HOMESTEAD NORTH AT STERLING RANCH FILING NO.3

STREET IMPROVEMENT PLAN

PCD-ENGINEERING REVIEW COMMENTS
IN BLUE BOXES WITH BLUE TEXT

SHEET 6 OF 15
 JOB NO. 2518812

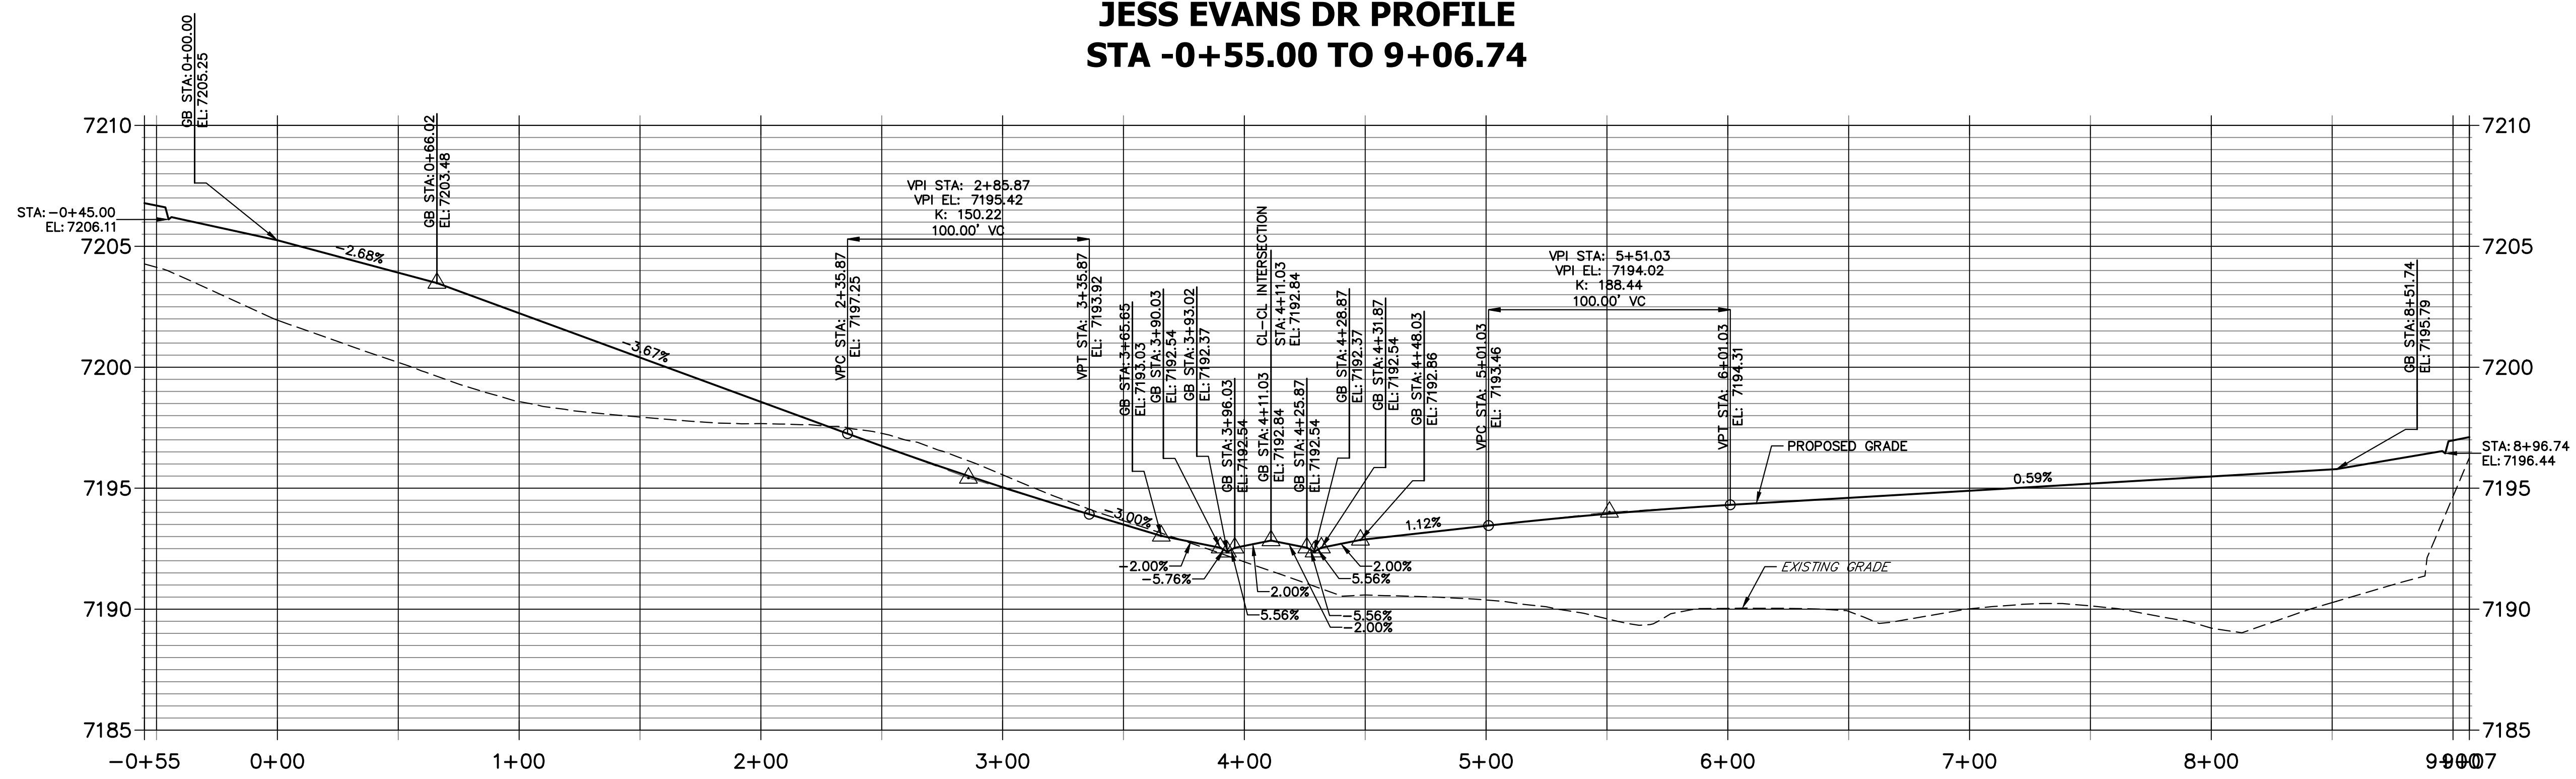
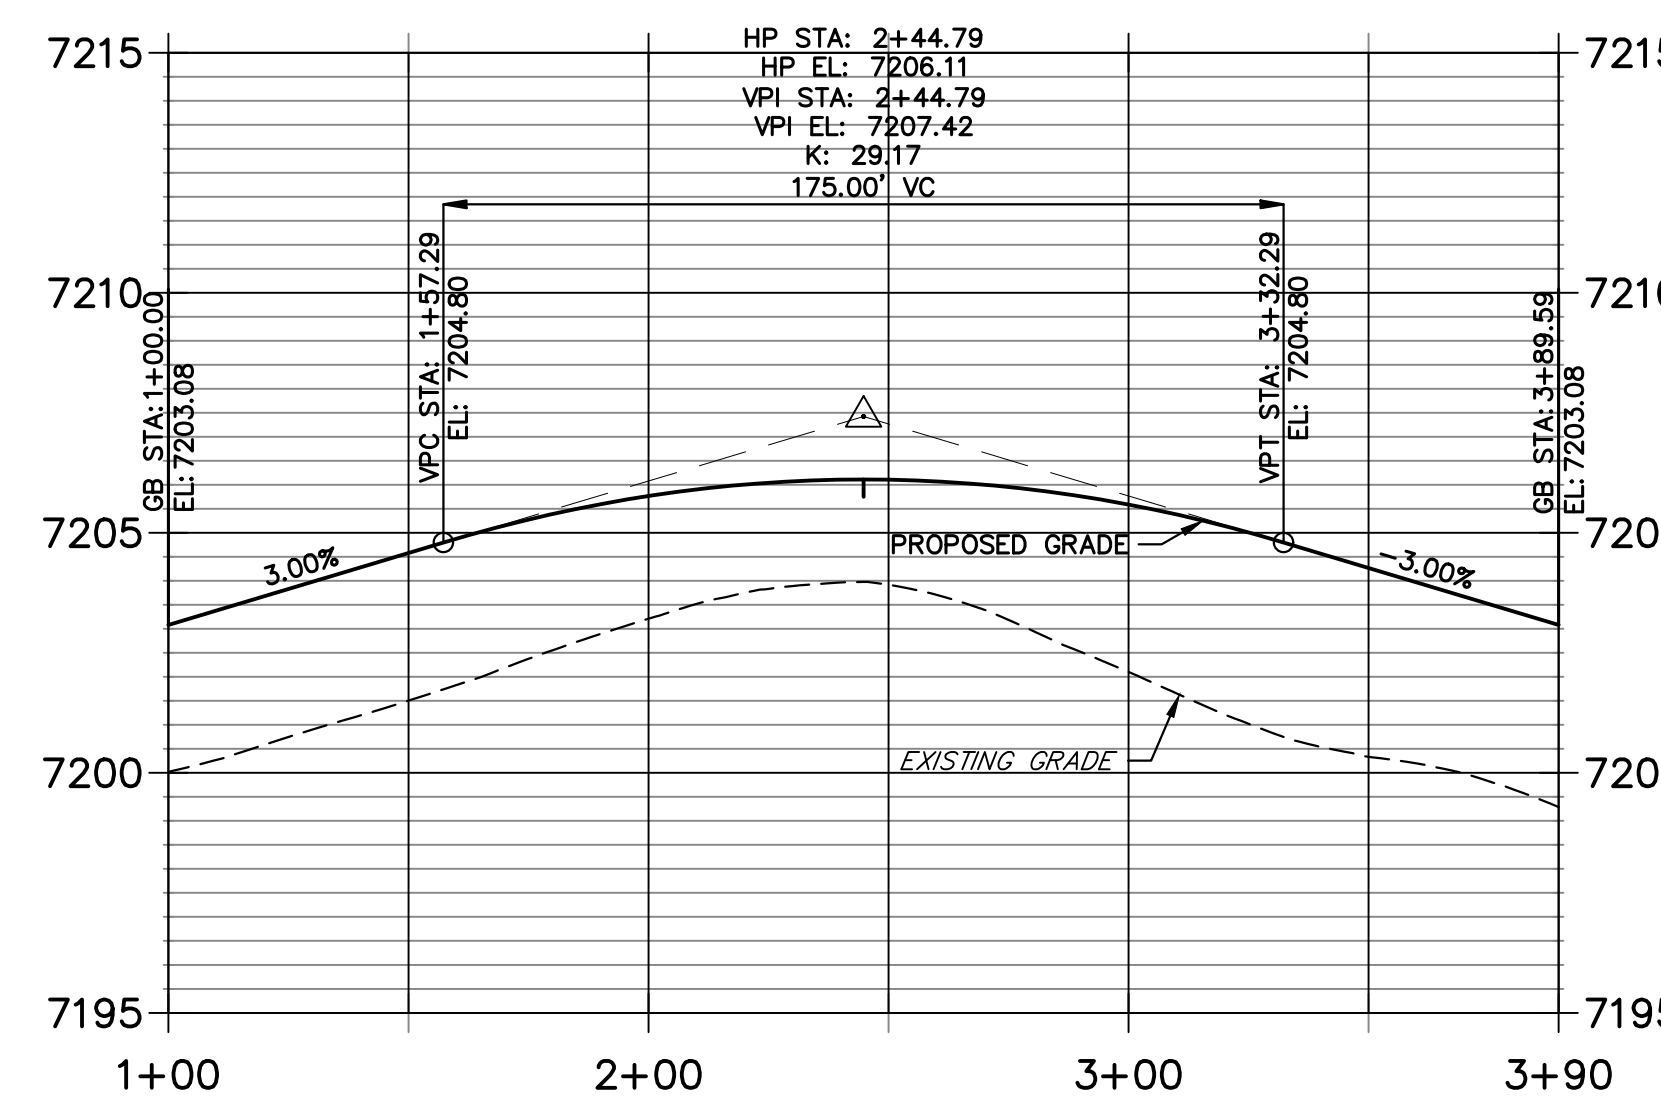
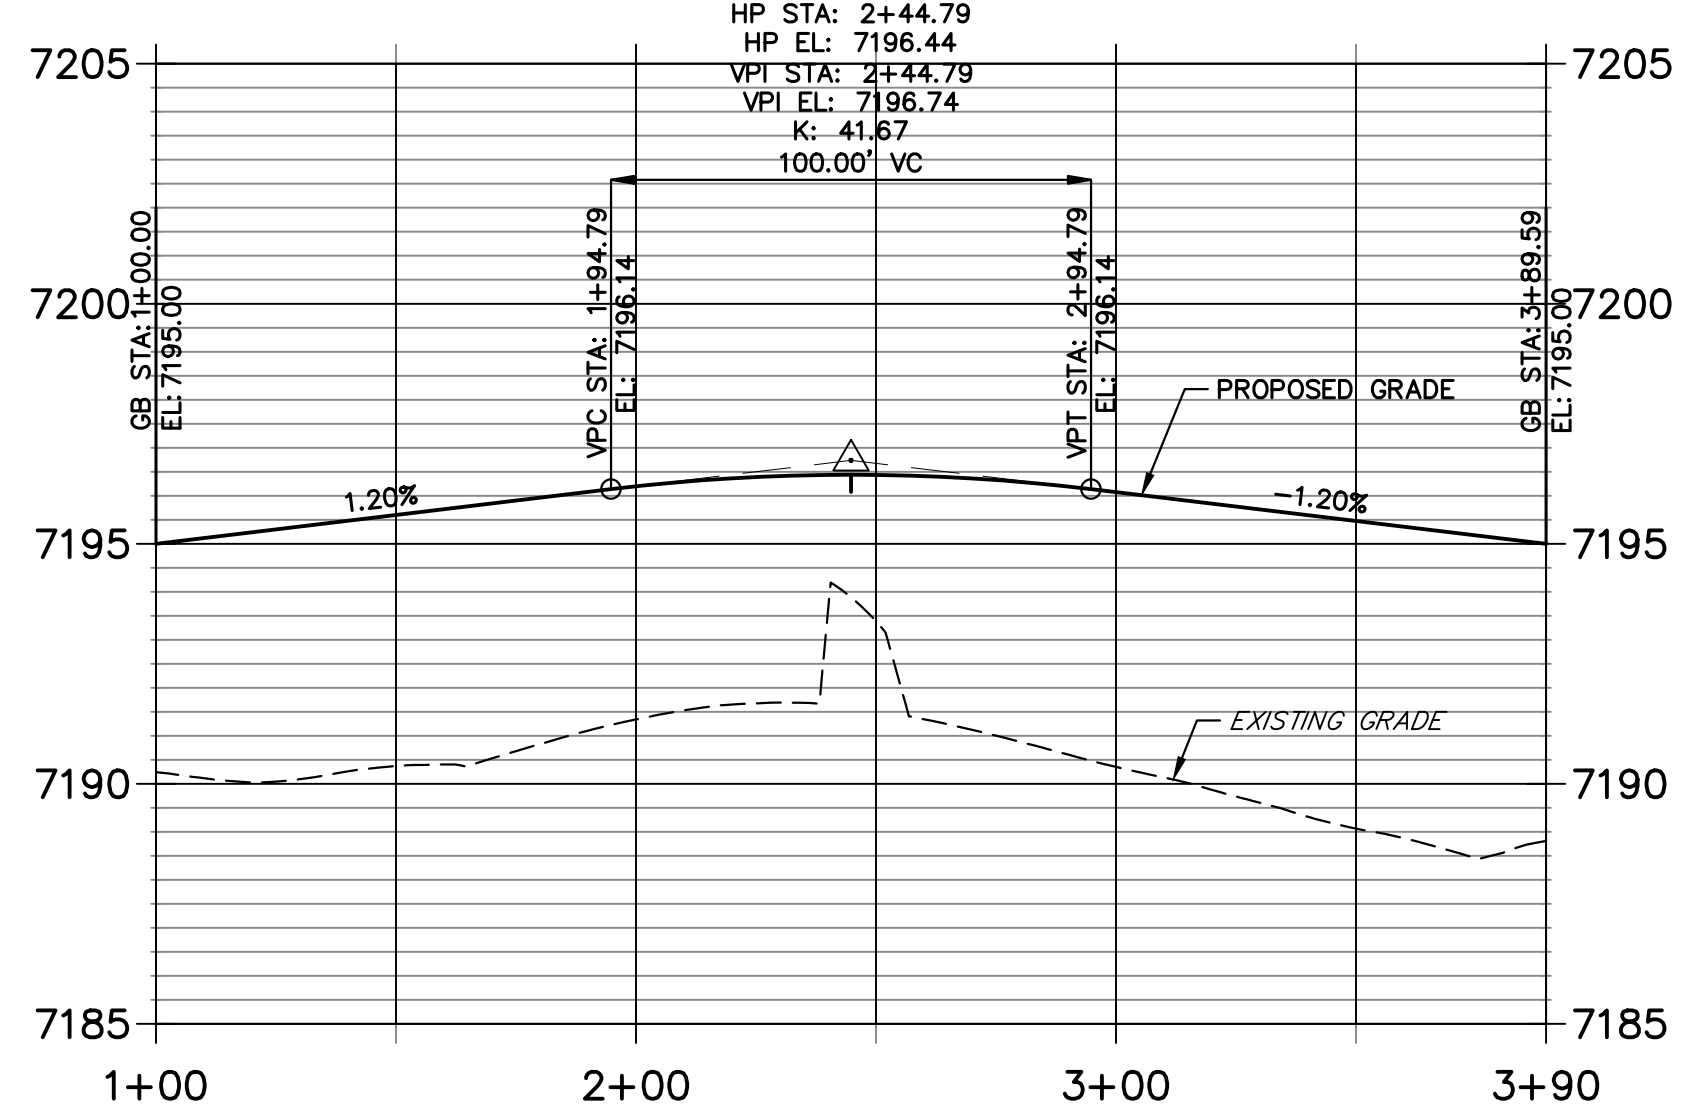
Doesn't match with elevation shown in point table
